From: Peter Davey [REDACTED]
Sent: 03 December 2019 14:55
To: Zac Denton
Subject: RE: AB/113/19/DOC - Query regarding application

From: Zac Denton [REDACTED]
Sent: 02 December 2019 14:17
To: [REDACTED]
Subject: AB/113/19/DOC - Query regarding application

client	project	drawing	date	drawn	drawing no	revision
Christine Fowler	New Doors / Windows at Dove Cottage, 13 Mount Pleasant Arundel, BN18 9BD	Window / Door Sections and New Eaves Detail	Dec 18	pd	0273 / 103	C
			scale	CAD file name:		
			1:5 @ A3

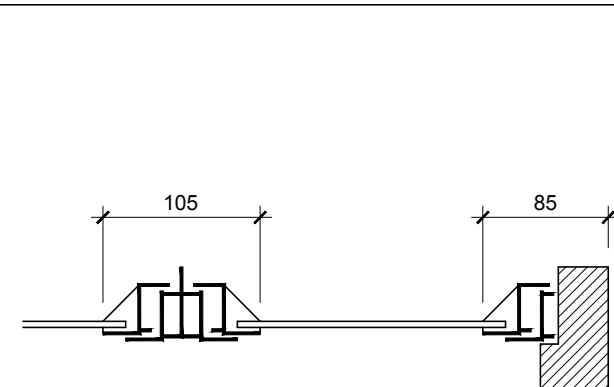
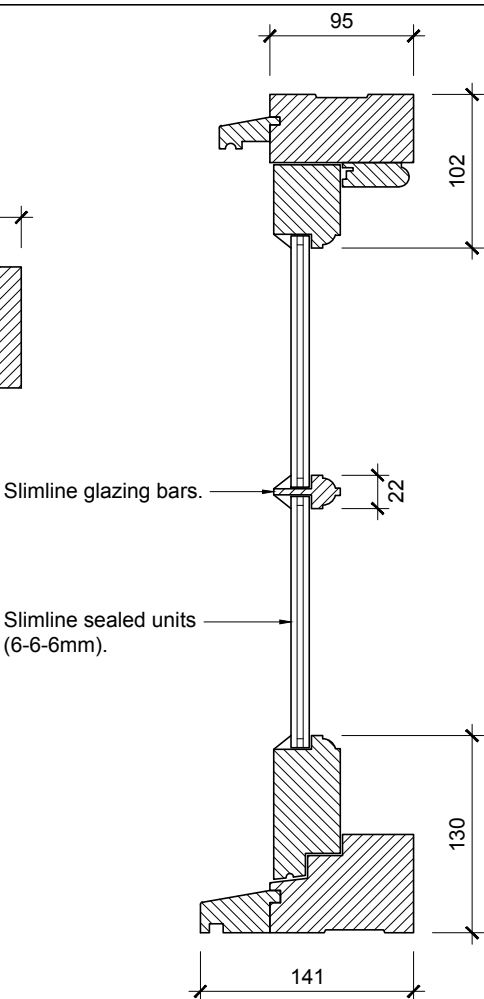
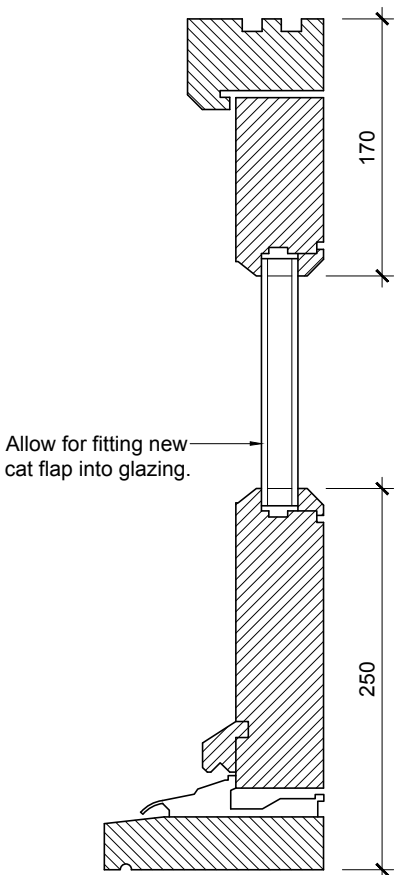
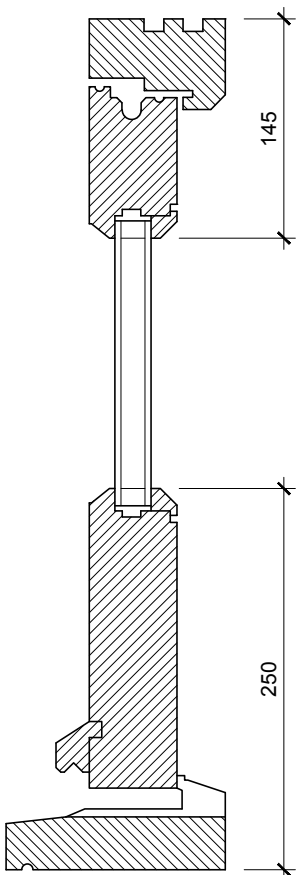
"The details of the joinery are acceptable. However, I note that the condition relates to the colour of the paintwork (for the windows/doors), and I cannot see any reference to this in the current application. If it is to remain the existing colour (white), no additional information is required."

I can confirm all of the replacement windows will be painted white.
